GWP Report No: 210602

02 June 2021

Post-ISH16 Technical Submission on Flood Risk Matters in Friston Village due to Scottish Power Renewables proposed EA1N and EA2 Onshore Works

**Plate 4.2 Outline Landscape Mitigation Plan (OLEMS (document reference 8.7))**

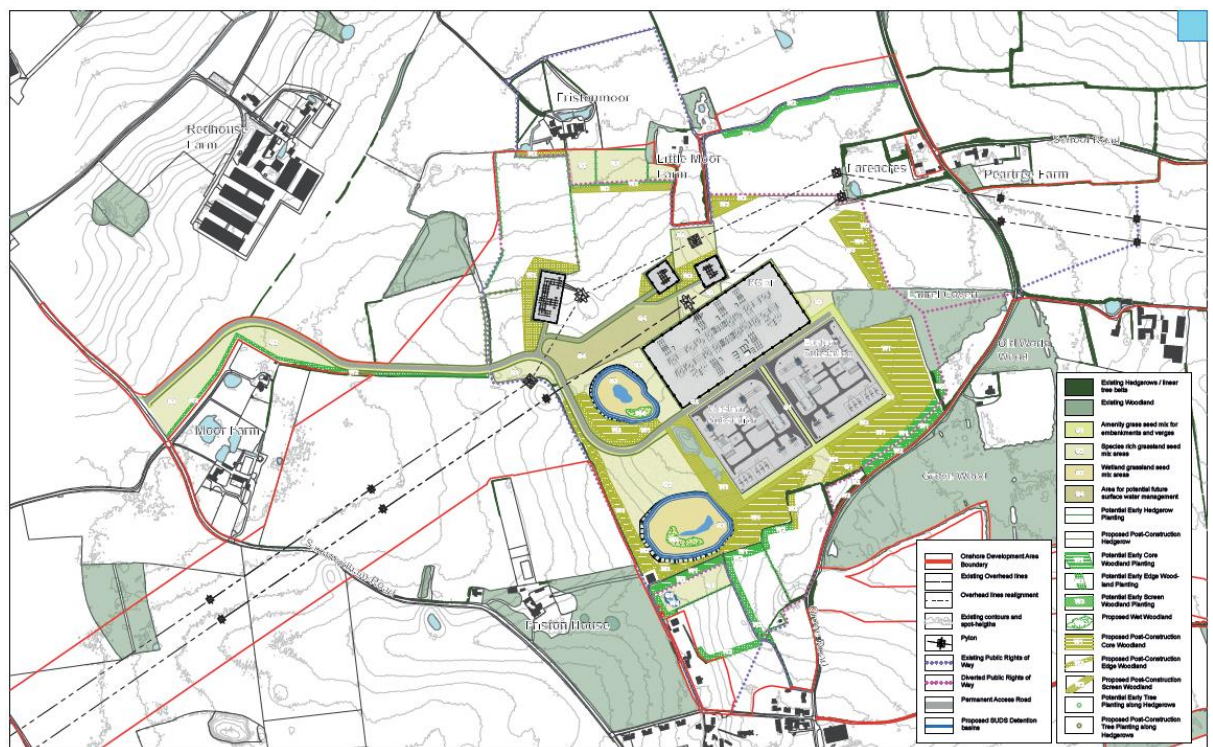
The Applicant confirmed the outline of the SUDS basins on the OLEMS drawings submitted immediately prior to ISH16 are smaller than those in their D9 submission.

SCC stated that they would not accept wet woodland inside the water storage structures nor on the bunds.

We GWP, on behalf of SASES, in addition to agreeing with the SCC position above, stated the use of soft or non-engineered landscape bunds was inappropriate and inconsistent with water retention structures of such size that if full of water would present a risk so substantial that ordinarily they would need to be regulated under the Reservoir Act. The risk of uncontrolled over-topping of such non-engineered bunds could result in catastrophic failure of the bunds and release of the entire water volume.

GWP stated this had not been mentioned in any information provided by the Applicant to date, and we do need see how this is consistent with the high value landscaping and biodiversity enhancement that the OLEMS is attempting to deliver.

The Applicant's response was that the bunds would be designed with engineered overflow structures.
